**The Children's Hospital at Westmead - Multi-storey Carpark (SSD-10434896)
Corner of Hawkesbury Road and Hainsworth Street, Westmead
Response to Submissions Report**

ATTACHMENT 1 – KEY ISSUES

1 PROPOSED ELEVATION - NORTH  
**North**

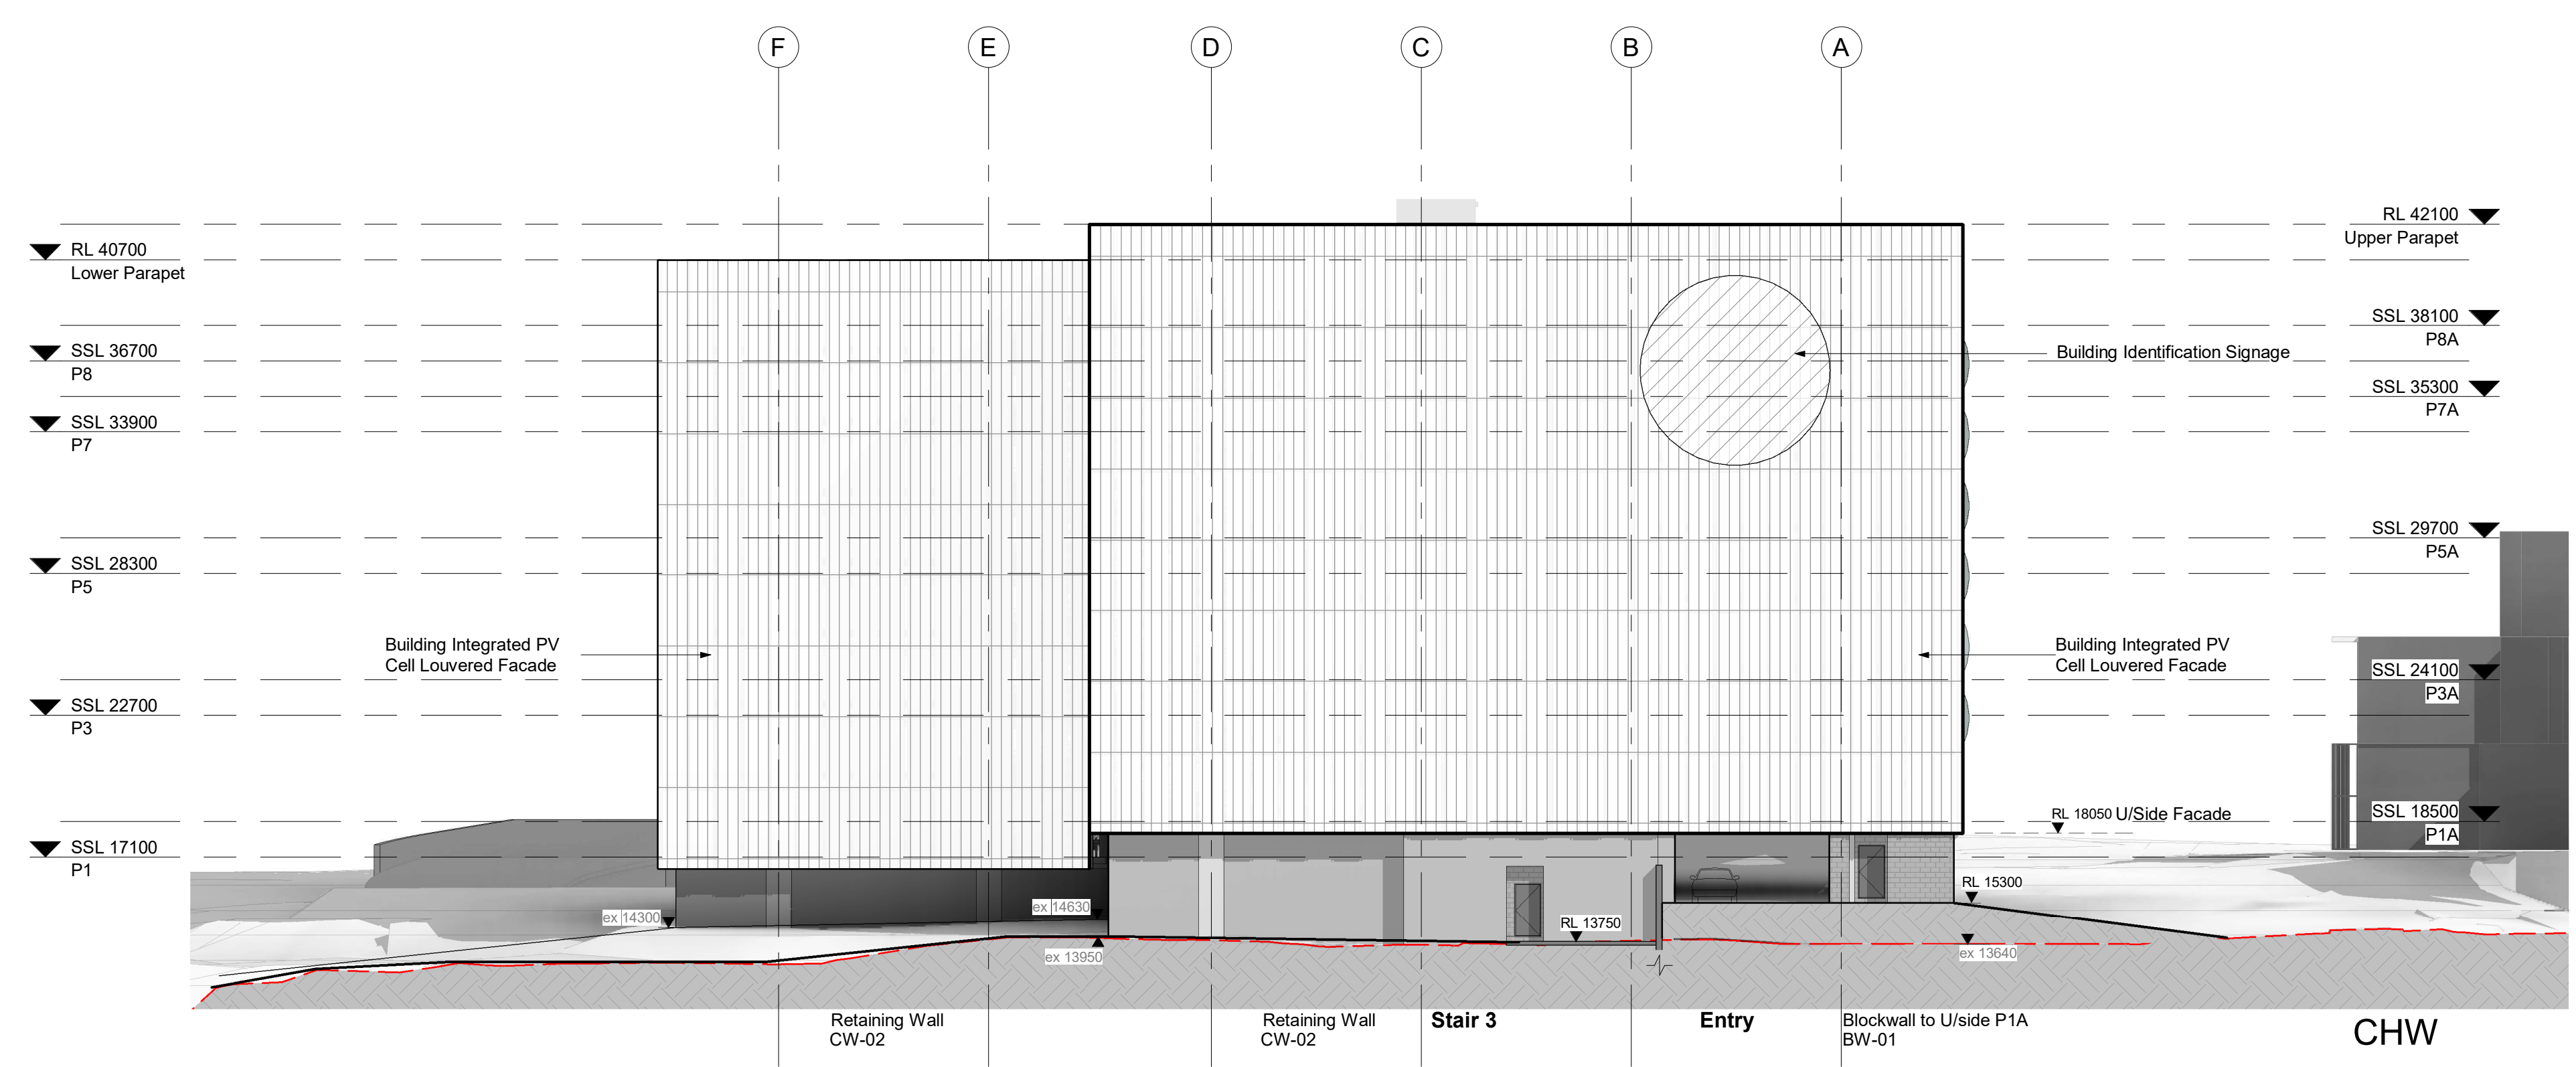
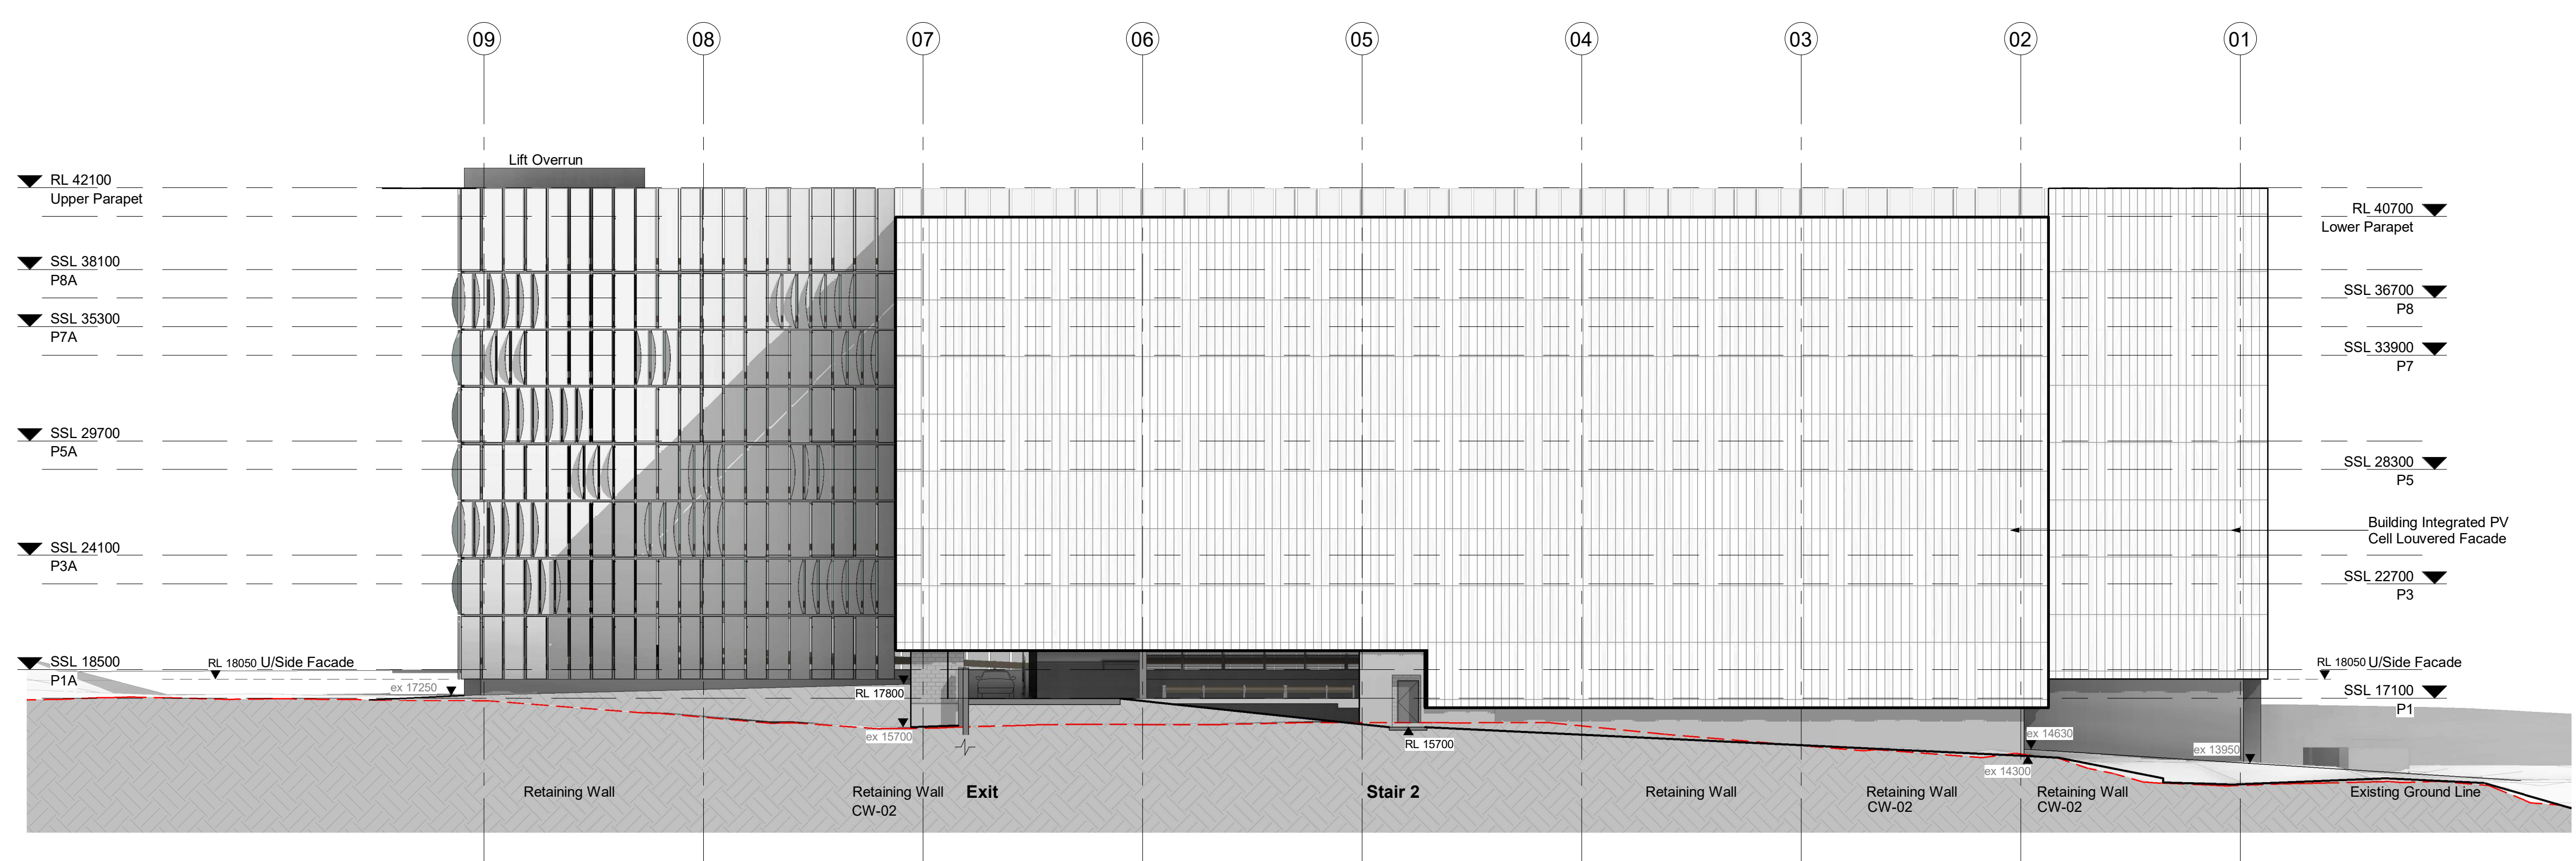
5. Updated architectural / landscape plans are to be submitted providing:
 - a) further detail of the proposed solar panel façade and/or roof canopy design in accordance with the ESD report.
 - b) confirmation of compliance with relevant Australian Standards for off-street parking facilities (parking space dimensions).
 - c) identify the location of motorcycle parking spaces.
 - d) the inclusion of public amenities, preferably in the vicinity of disabled parking spaces.
 - e) the integration of a retail offering adjacent to the kidsway and playground area.
 - f) the detailed design of the new universal access playground, including an investigation into potentially relocating these facilities to the vacant turfed area opposite the Remembrance Garden to enable improved solar access.
